**WELWYN HATFIELD BOROUGH COUNCIL
ASSISTANT DIRECTOR (PLANNING)**

DELEGATED APPLICATION

Application No: 6/2024/0192/FULL
Location: 182 Dragon Road Hatfield AL10 9NZ
Proposal: Change of use from a dwelling house (Class C3) to a children's home (Class C2)
Officer: Ms Ashley Ransome

Recommendation: Refused

Sheet Title
Maps

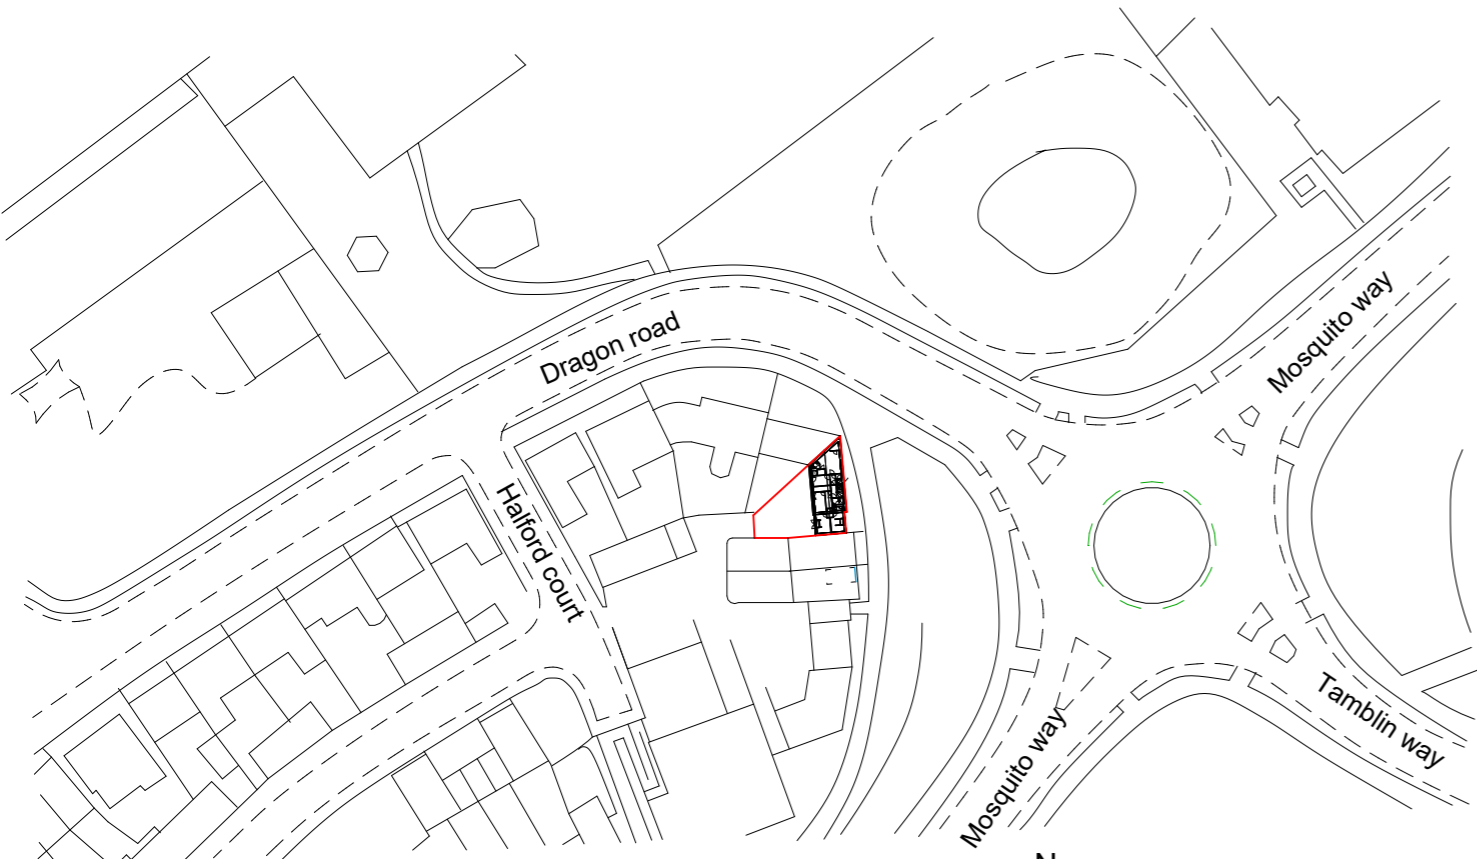
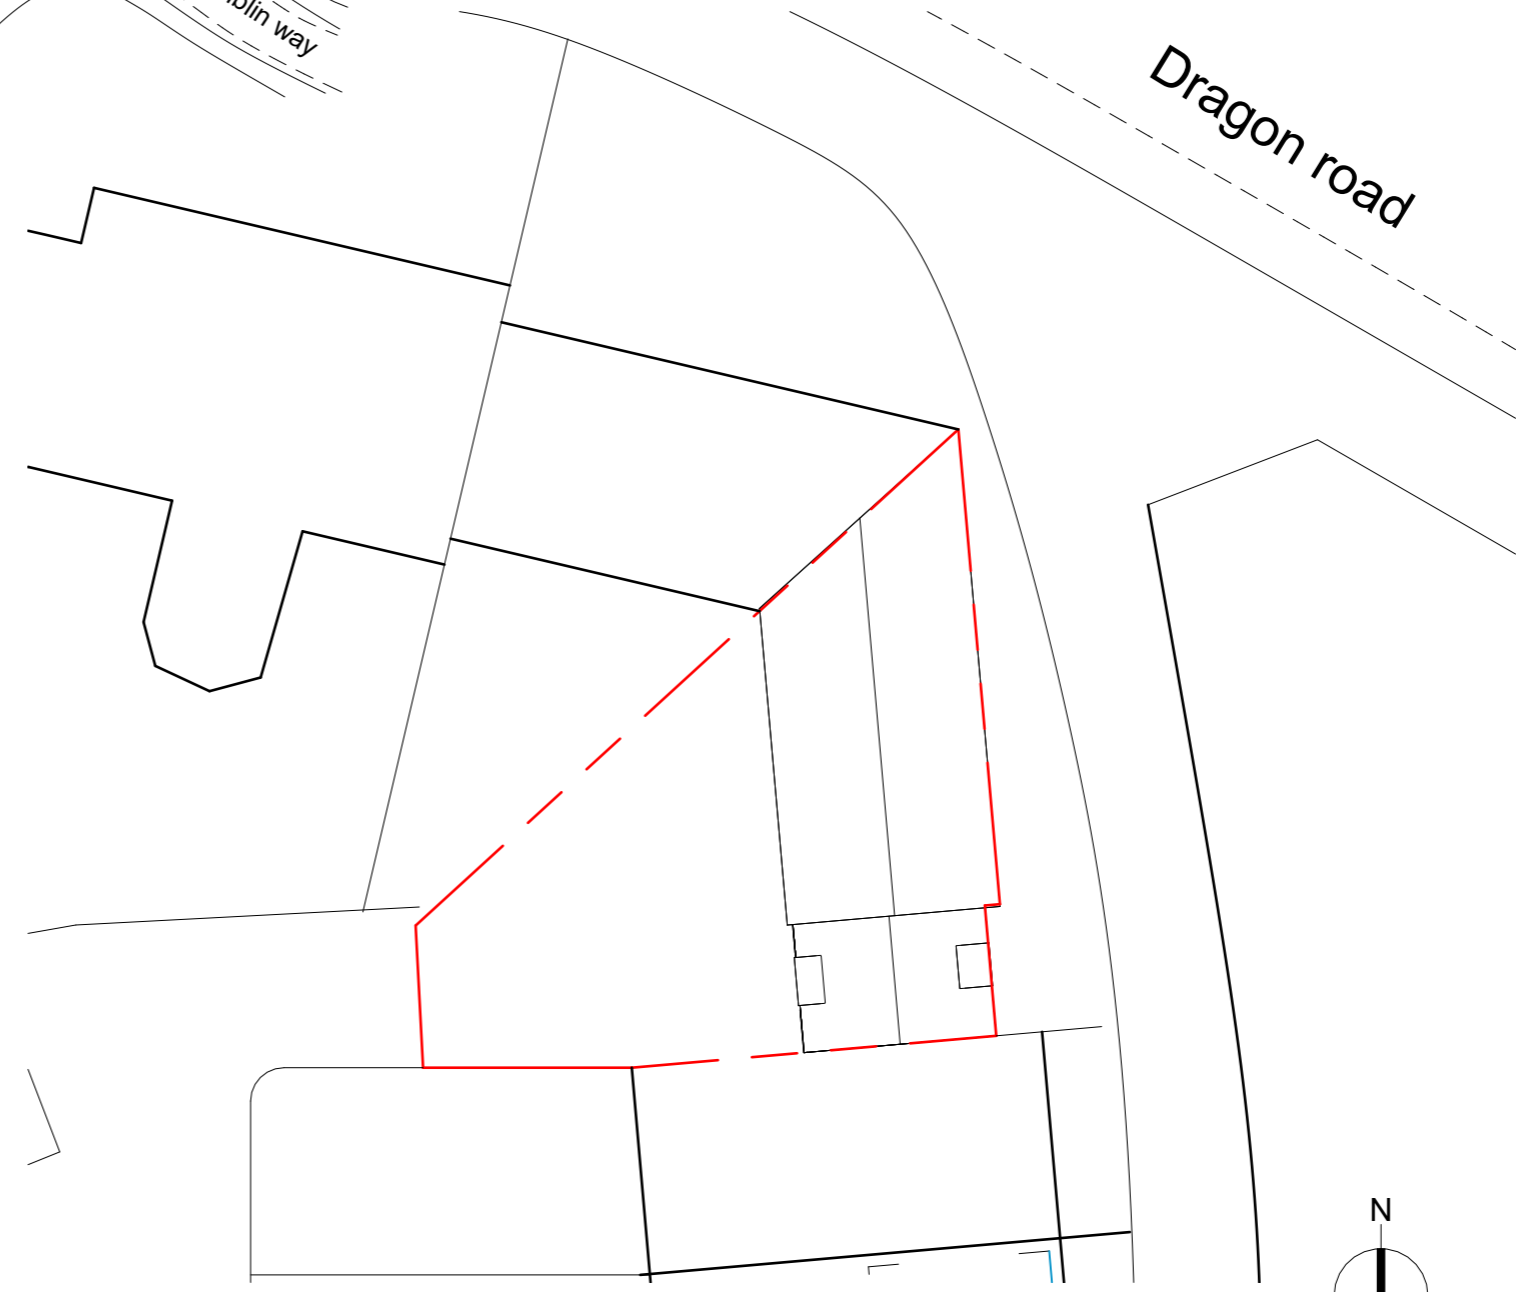
<p>are provided within the courtyard to the rear. The red line boundary on the location plan solely encompasses the site only, with the two courtyard spaces located outside of this. The application is therefore assessed on the basis that there would be one off-street parking space.</p> <p>During a recent site visit, Officers witnessed a considerable number of vehicles parking on the street. No vehicles were parked on verges or footways as there are restrictions in place. A restriction between 8am-6pm Monday to Friday is also in place to allow only resident permit holders to park between these times. A discussion with the WHBC Parking Services Team surrounding parking permits during the course of similar applications established that permits would not be granted for managers/careers employed at the site as they do not fall into one of the parking permit holder categories. The application is not supported by any travel information to explain how the development would operate. There is no specified end use for the development, and it is important that adequate access and parking arrangements are provided for disabled persons. The application does not address the accessibility needs of any disabled residents, visitors or employees, thus it is considered that the proposal provides inadequate access and parking arrangements for disabled persons.</p> <p>Dragon Road and the surrounding area is built to a relatively high density and sees narrowing of roads and a tight highway geometry, and these features, together with parking controls, limit the ability to conveniently or safely park on the highway. The use would add to parking pressures within the vicinity, and this would be harmful to the convenience and safety of other road users.</p> <p>The absence of parking for the use is neither safe nor suitable to safely cater for the traffic movements from the application property. In addition, any displaced parking and increase in parked vehicles along the narrow street road would add to the cluttered nature of the environment and as such would cause some, albeit limited, harm to the character and appearance of the area.</p> <p>It is acknowledged that the application site is within walking distance of local shops and facilities and to bus routes, and so, public and other non-car means of transport are viable travel options. However, given the particular circumstances of the use discussed above, it is concluded that the development does not provide adequate off-street parking to the detriment of highway safety and character and appearance of the area. As such, the proposal conflicts with Policies SP9, SADM2 and SADM12 of the Welwyn Hatfield Local Plan; the guidance in the Council's Supplementary Planning Guidance Parking Standards 2004, the Interim Policy for Car Parking Standards and Garage Sizes, and the National Planning Policy Framework. Together, these policies and guidance aim to ensure that development achieves a sensible level of parking taking into account existing standards, national policy, and local circumstances. It also conflicts with Chapter 9 of the NPPF which, amongst other things, sets out that safe and suitable access should be achieved for all users and the needs of people with disabilities and reduced mobility should be addressed.</p>

Sheet Title  
**Proposed Plans**

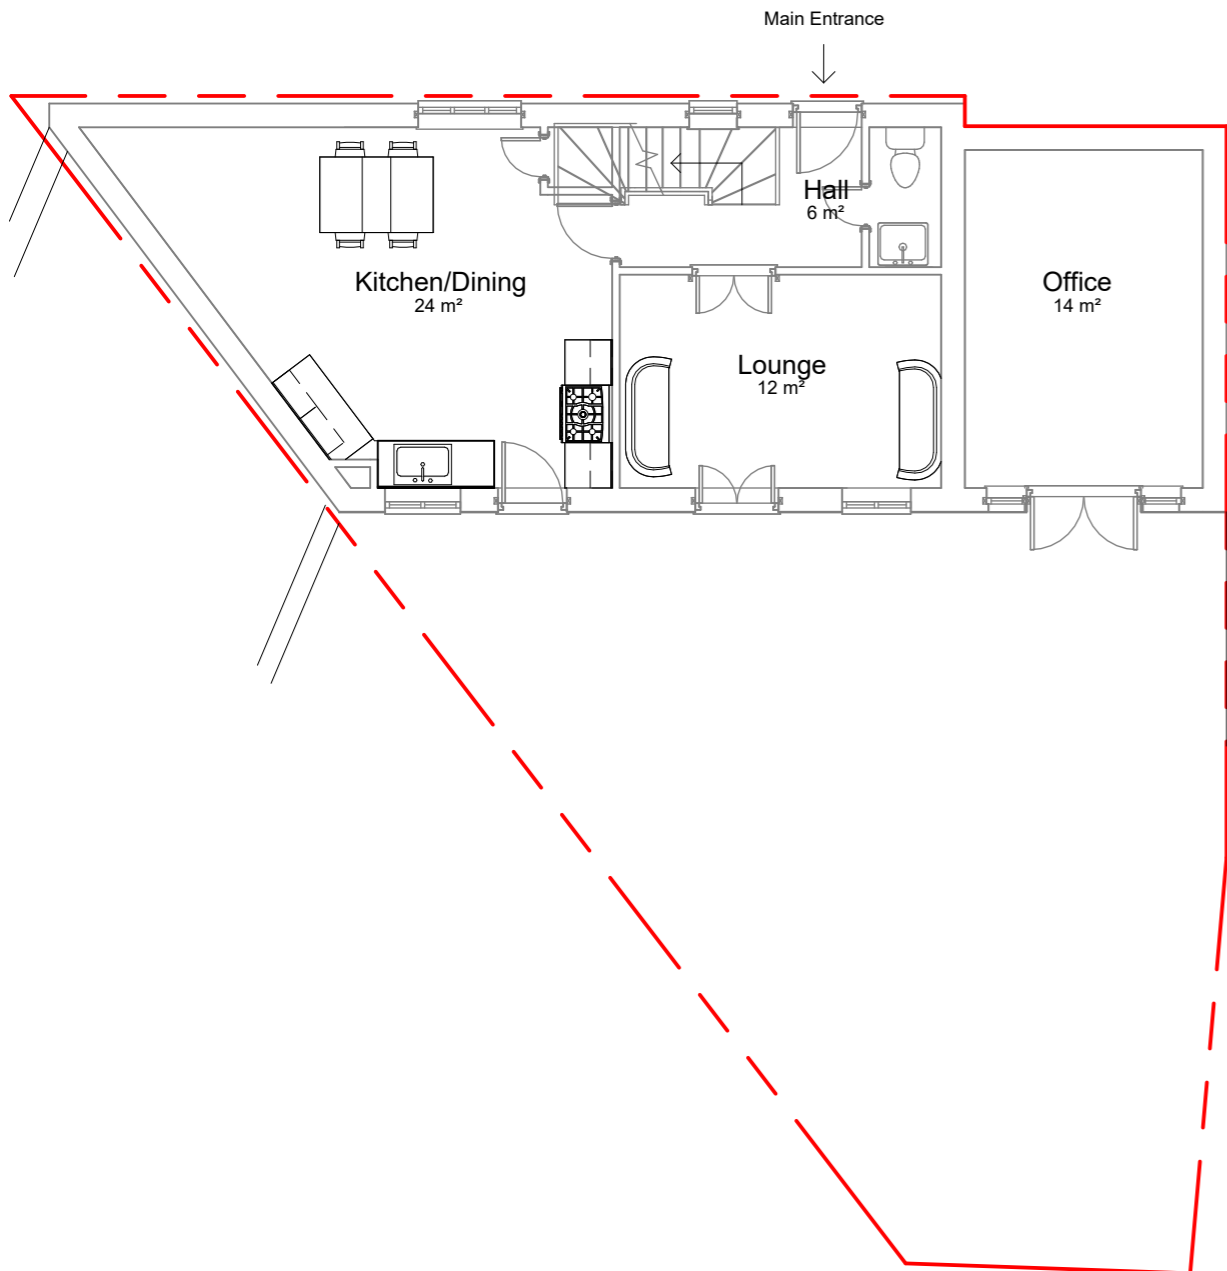
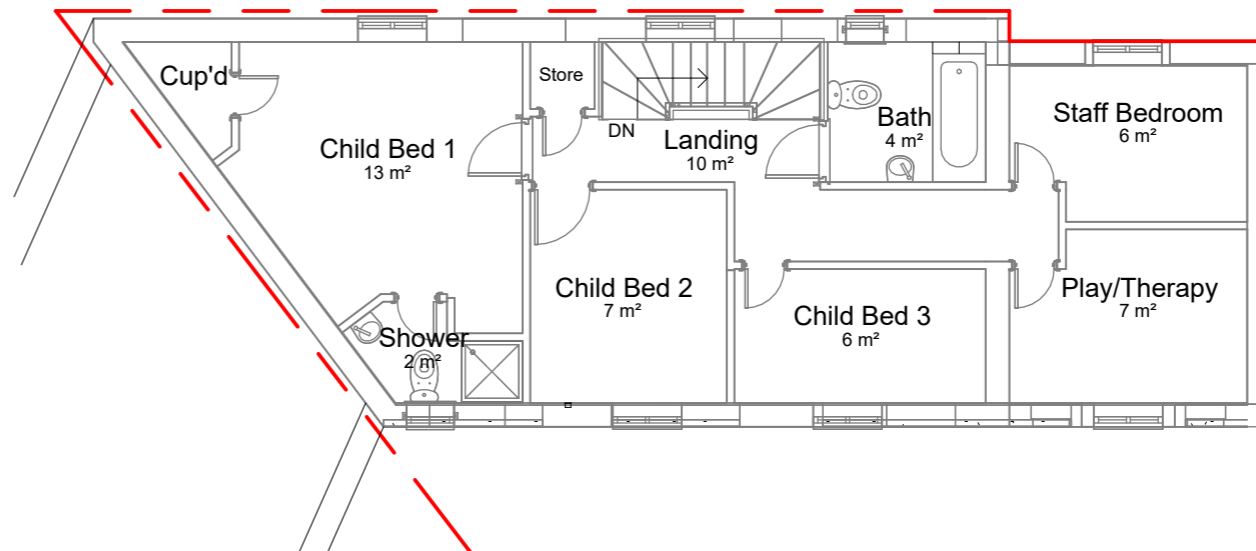
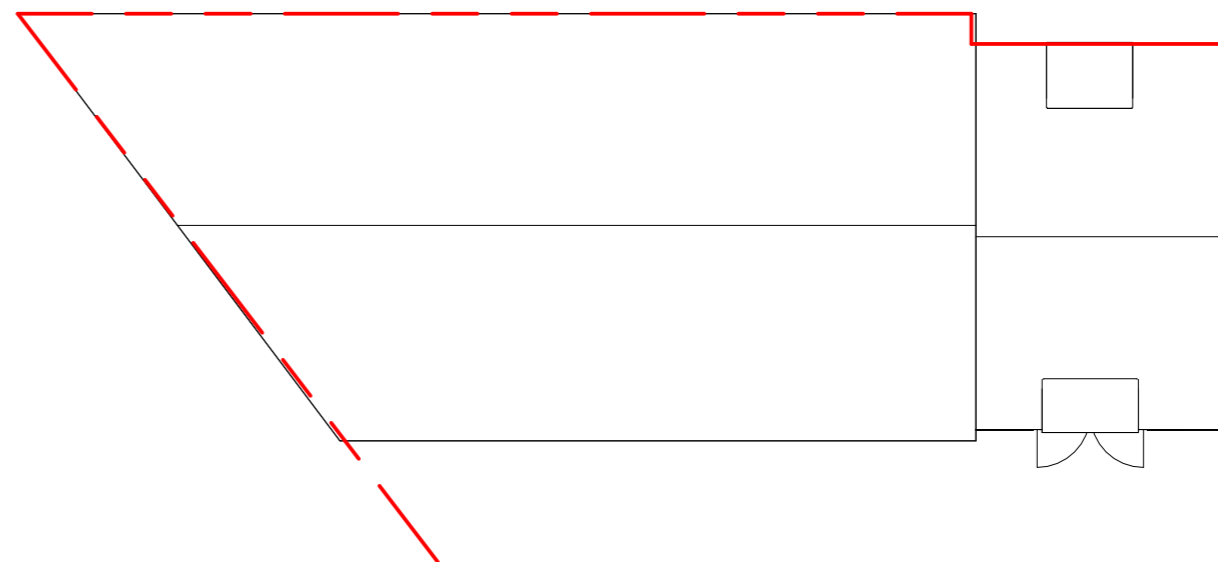
Consultees and responses	<p>WHBC Public Health and Protection – No issues to raise.</p> <p>Hertfordshire Constabulary – I note the intended staffing levels, which are good. There is a concern that the intended office in the garage has no</p>

<p>connection to the main house. Staff in office will be separated from activities in the main home and therefore unable to react to situations appropriately. A linking door should be fitted (PAS24 rated unless existing exterior garage door is already PAS24, which is unlikely). The requirement to register with Ofsted must be a condition of planning, to ensure the establishment is a bone-fide care home. With these matters addressed, I would be able to support this application.</p> <p>WHBC Client Services – There would be no changes to the current domestic waste services provided.</p> <p>Children’s Services, Hertfordshire County Council – No response received.</p> <p>Hatfield Town Council – No response received.</p>
--	---

The Nationally Described Space Standards sets out that the floor space of a double bedroom should measure at least 11.5m², whilst the floor space of a single bedroom should measure at least 7.5m², and at least 2.15m wide. From observing and measuring the submitted floor plans, there would be one double bedroom with a floor space of approximately 13m², thus meeting the Nationally Described Space Standards for a double bedroom. There would be two single bedrooms provided for children, and a further single bedroom provided for staff. One single bedroom for a child would have a floor space of approximately 7m² and have a width of approximately 2.5m, whilst the other single child bedroom would have a floor space of approximately 6m². The staff bedroom would have a floor space of approximately 6m². Two bedrooms do therefore not meet the Nationally Described Space Standards for a single bedroom. It is however acknowledged that these bedrooms remain as existing, along with the consideration that the proposal would not be for a new dwelling and thus the standards are therefore only guidance. Moreover, the bedrooms would likely be for a single occupant due to the nature of the proposed use as
